RMS Ref: SYD15/00307/05 (A10858368)

Council Ref: SSD 6980

EXHIBITION OF EIS FOR BROOKVALE COMMUNITY HEALTH CENTRE
612-624 PITTWATER ROAD, BROOKVALE

APPENDIX B: VEHICLE TURNING PATH PLANS

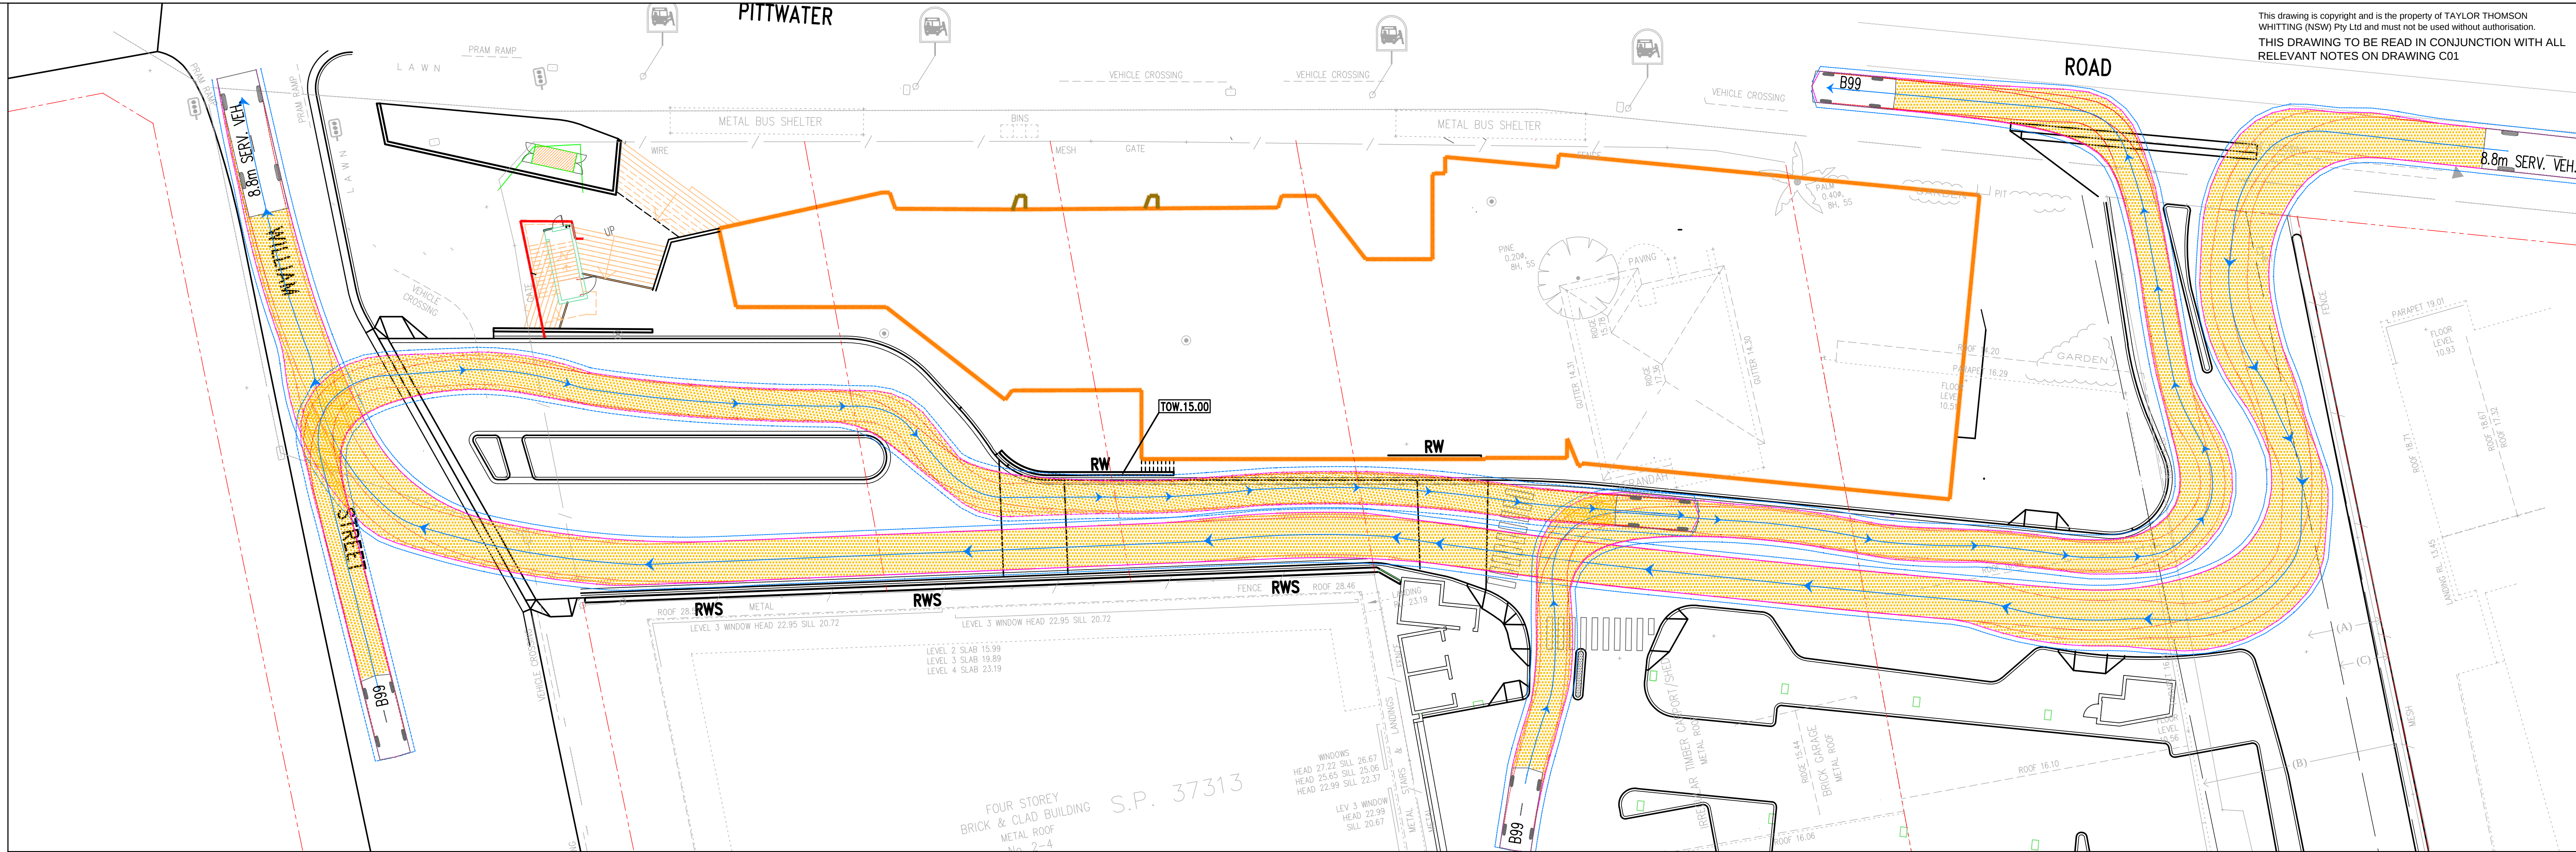
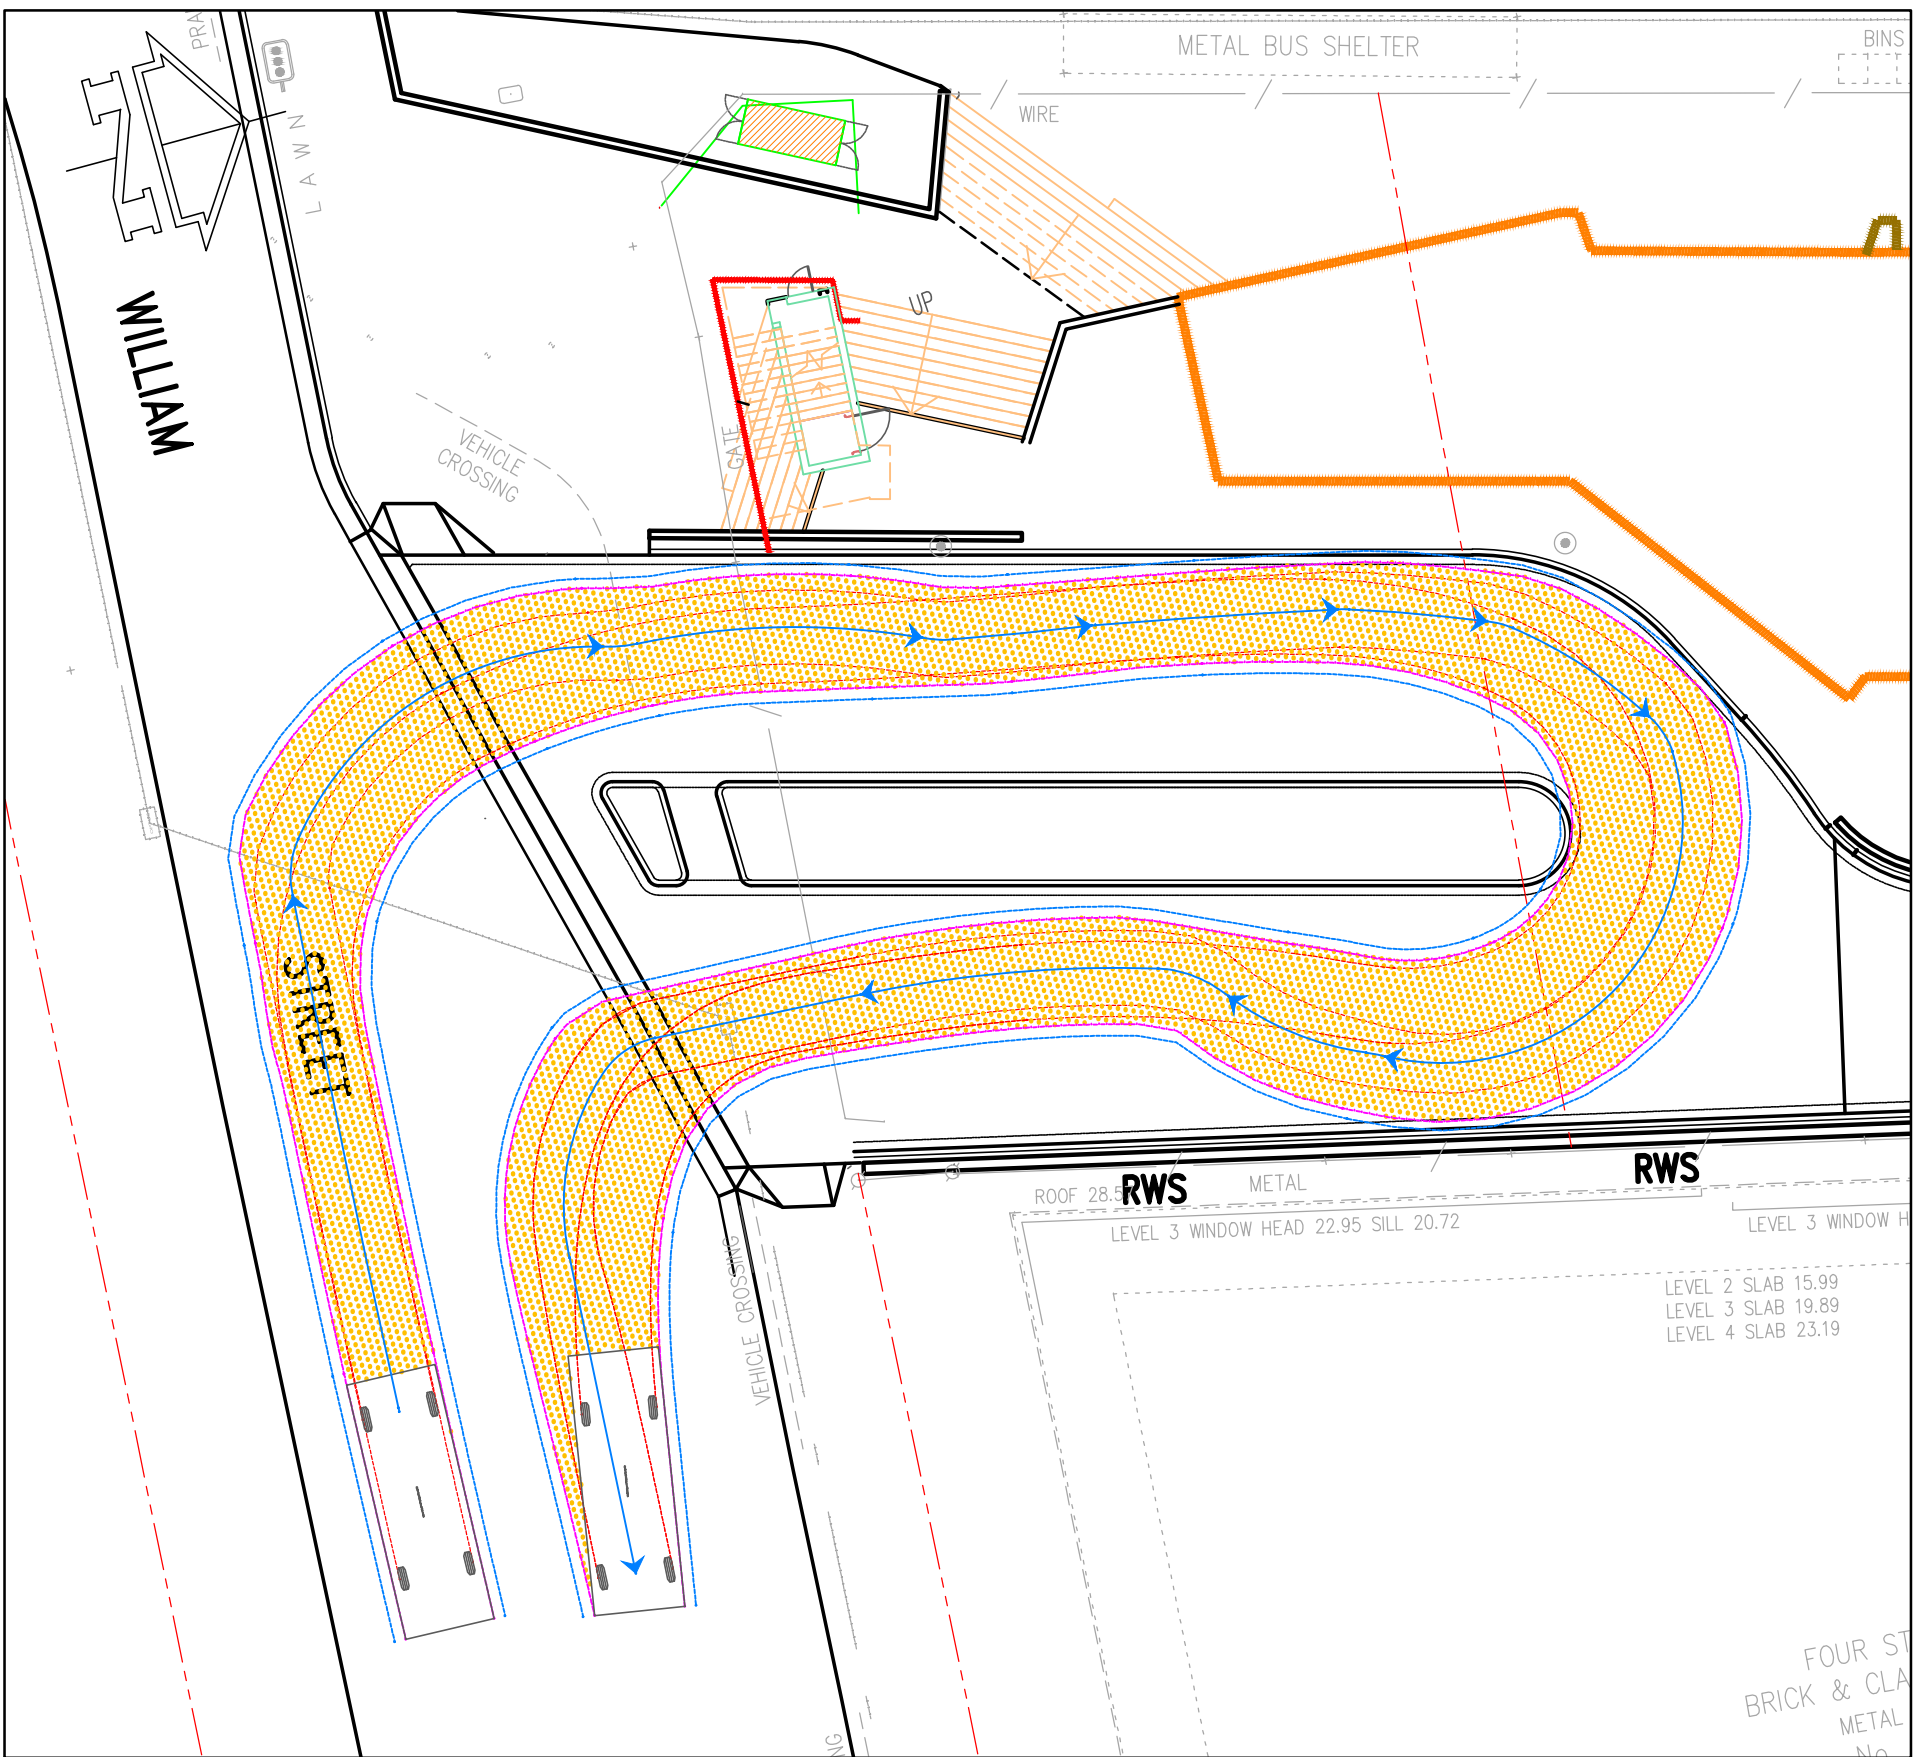
3. The swept path of the longest vehicle (to service the site) entering and exiting the subject site, as well as manoeuvrability through the site, shall be accordance with AUSTROADS. In this regard, a plan shall be submitted to Council for approval, which shows that the proposed development complies with this requirement.
